Subject: BN/99/19/HH

BN/99/19/HH

PROJECT:
Barnham Court, Church Lane, Barnham
Elevation of Front Entrance with proposed Gates

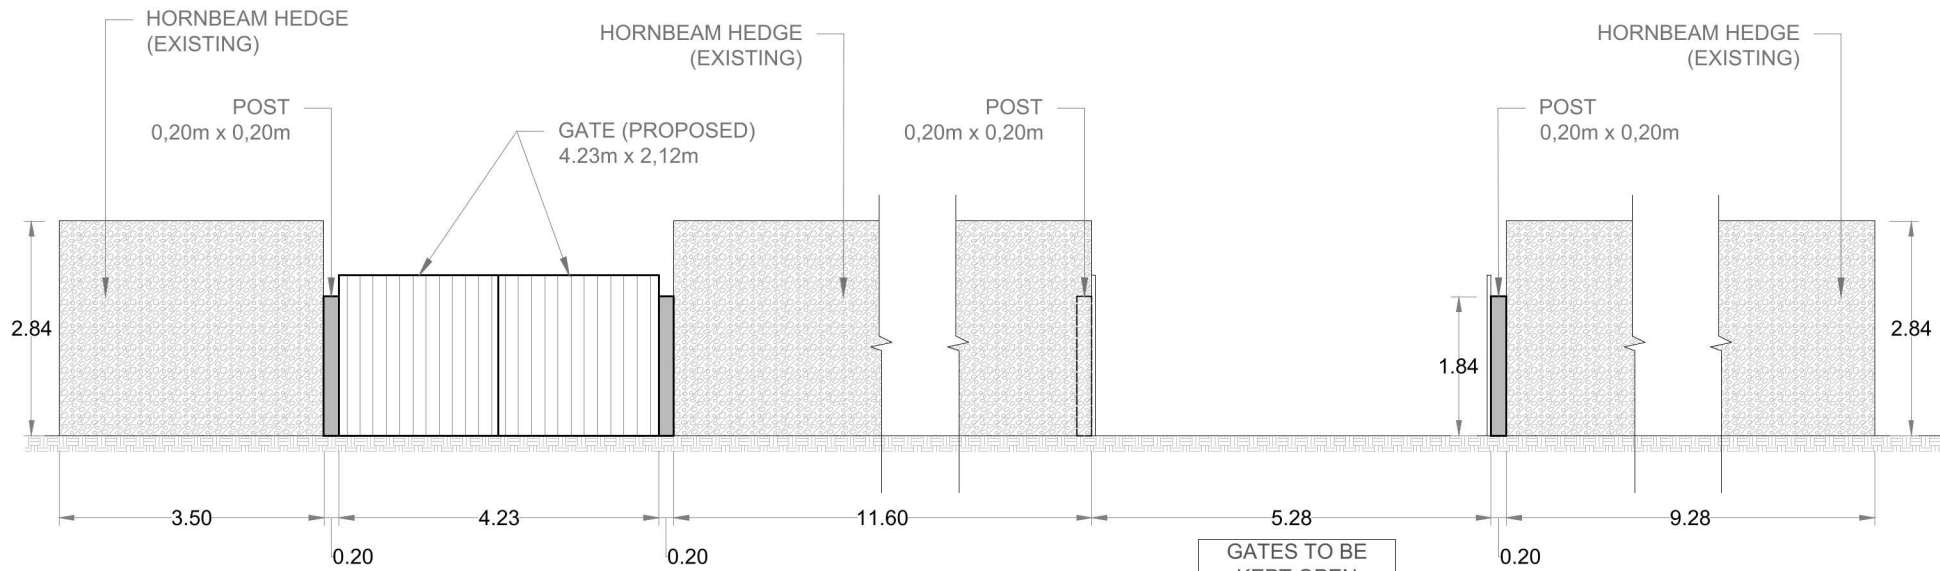
Vehicular gates at both entrances to property fronting Church Lane: it is noted that the gates will be attached to pre-existing oak posts. These are to be of a similar design to others nearby on the site. The intention to ensure that one set of the gates remains open at all times is supported as it will allow some views of the drive to remain. It is therefore considered that, on balance, the presence of these gates will not harm the character of the local area, nor the setting of the other assets in the local area.

The design of the gates and their colour should match the other existing gates on the application site

PROJECT:
BARNHAM COURT, CHURCH LANE, BARNHAM
"GATE FRONTING CHURCH LANE"

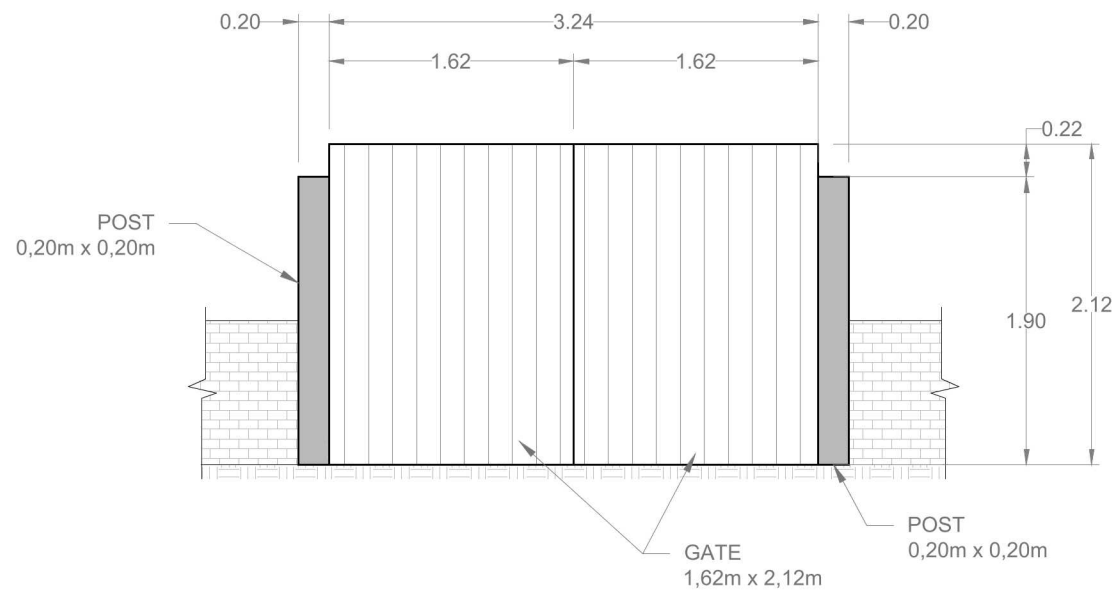
Vehicular and Pedestrian Gates: The vehicular gate and pedestrian gates have already been installed and are of a design and appearance that does not detract from the established character of the area.

PROJECT:
Barnham Court, Church Lane, Barnham
Vegatal Pergolas (N&S) in Front Garden (proposed)

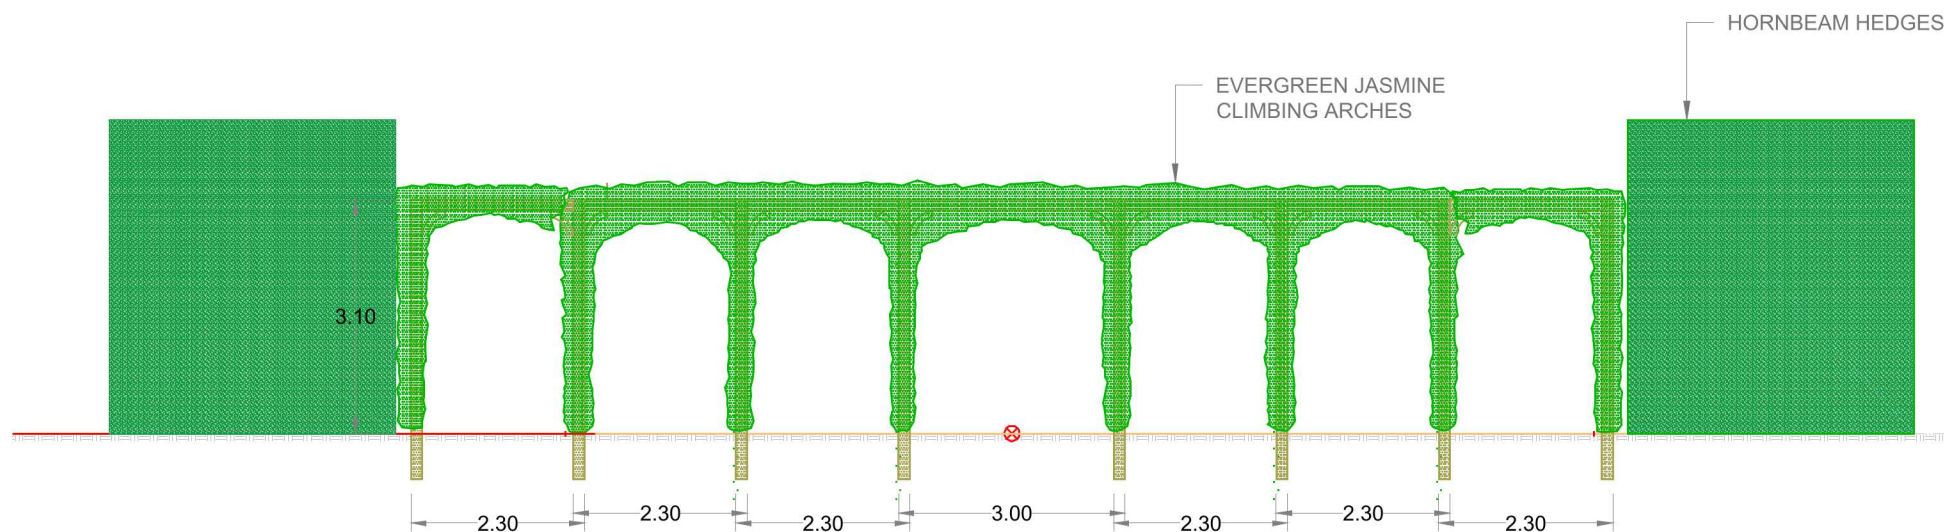
Vegetal Pergolas (proposed): The two-vegetal pergola will be located in the garden area to the front of the site and are intended to be plant support structures in the Anglo-Dutch garden. They will be located between the existing northern and southern hornbeam hedges and form part of the existing garden layout. It is considered that whilst they are large in scale, that they will complement the existing garden layout and on balance have a neutral impact upon the heritage assets.
